From: Raymond Turner 
Sent: 09 August 2018 18:03
To: Simon Davis; Planning
Cc: Raymond Turner; Chris Reid
Subject: EG/43/18/PL

Ref: EG/43/18/PL 15-06-2018

An Objection to the proposed Change of use from shop (A1 Shops) to micro-pub (A4 Drinking Establishment).
at 42 Barnham Road Eastergate

PROPOSED GROUND FLOOR PLAN 1:100

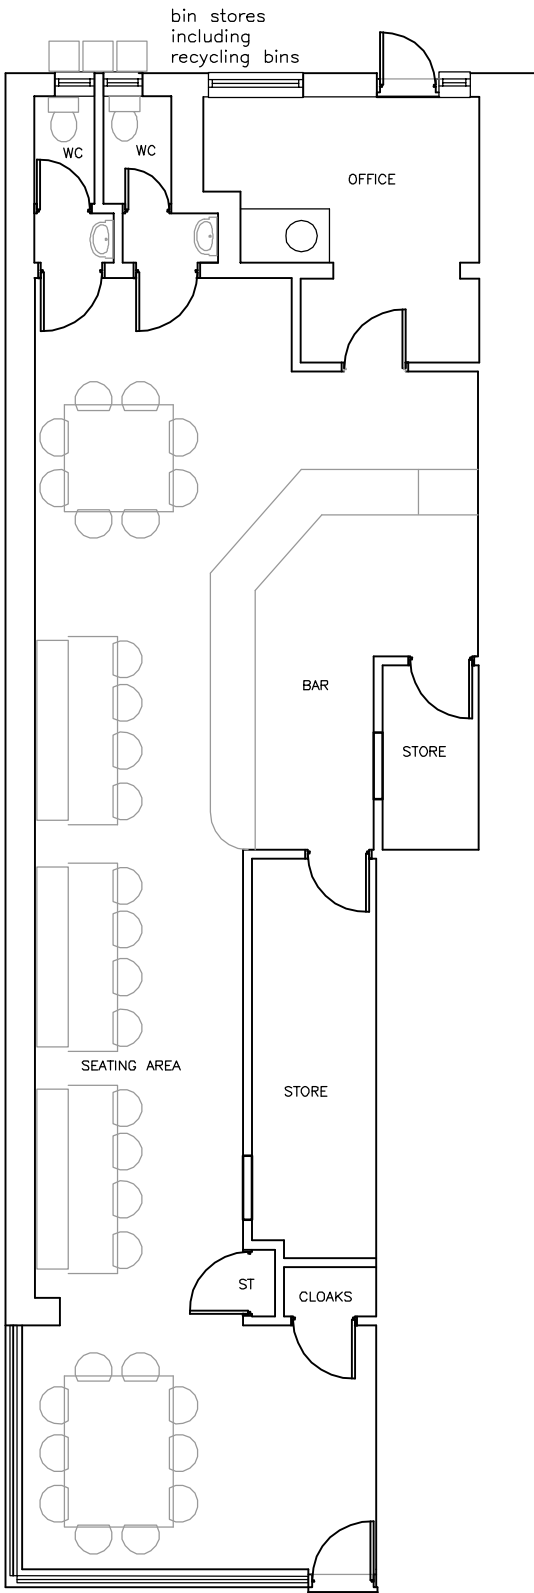
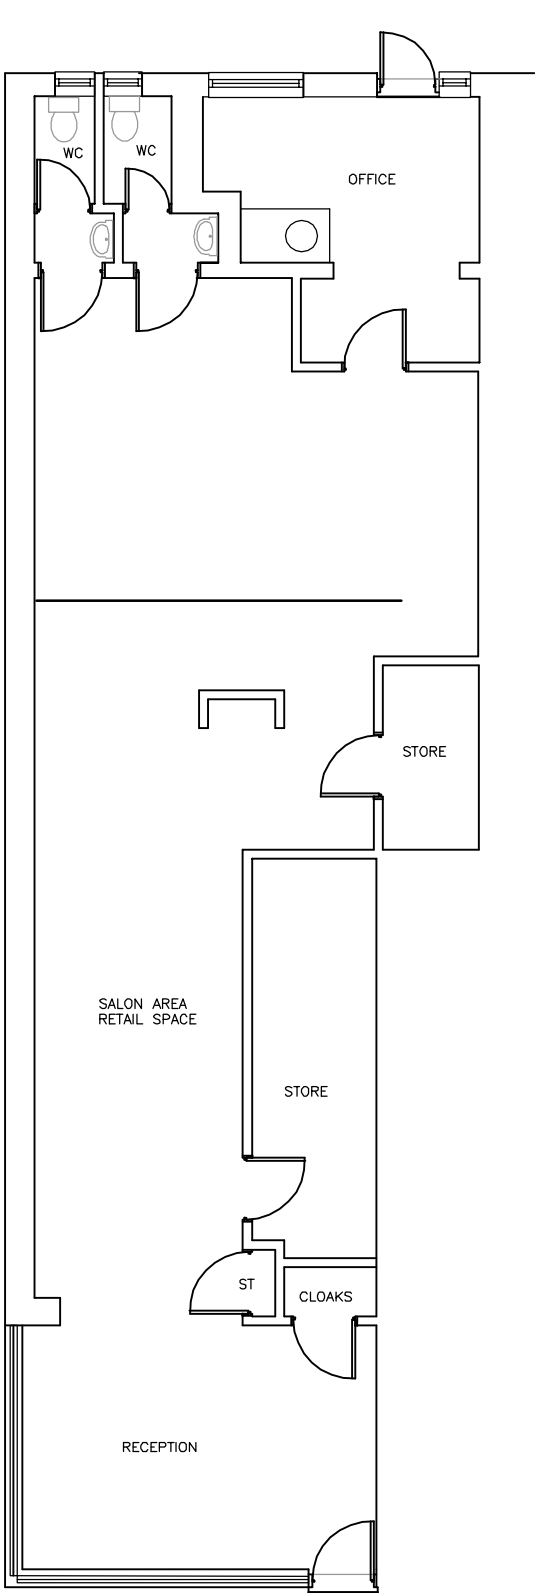
Proposed Poled Off Out Door Seating area for 8 people.

The proposed seating area for 8 people will cause a hazardous obstruction and a potential risk by protruding on to the pavement and will therefore significantly narrow the public pathway/walkway and almost blocking access to the dropped kerb's which are situated on the corner on both sides of the road at the entrance of Saxby close. The dropped kerbs are there to serve an important purpose and are therefore extremely crucial to people with mobility/disability issues and parents with small children and pushchairs and of course safety for the elderly.

A clear route/walkway should be maintained at all times for passing pedestrians without causing hindrance or obstruction, The layout of the seating area should not protrude on to the public walkway so as not to cause a hazardous obstruction/restriction by way of forcing the passing pedestrians/public to dangerously diverting their narrowed pathway even closer to an already busy main road.

This will also cause an inconvenience to the existing residents living above the proposed premises by causing a hazardous obstruction to their communal door entrance. Also, passing pedestrians/public with disabilities and or Mobility issues would also suffer as a result of a dangerously/hazardous narrowed walkway.
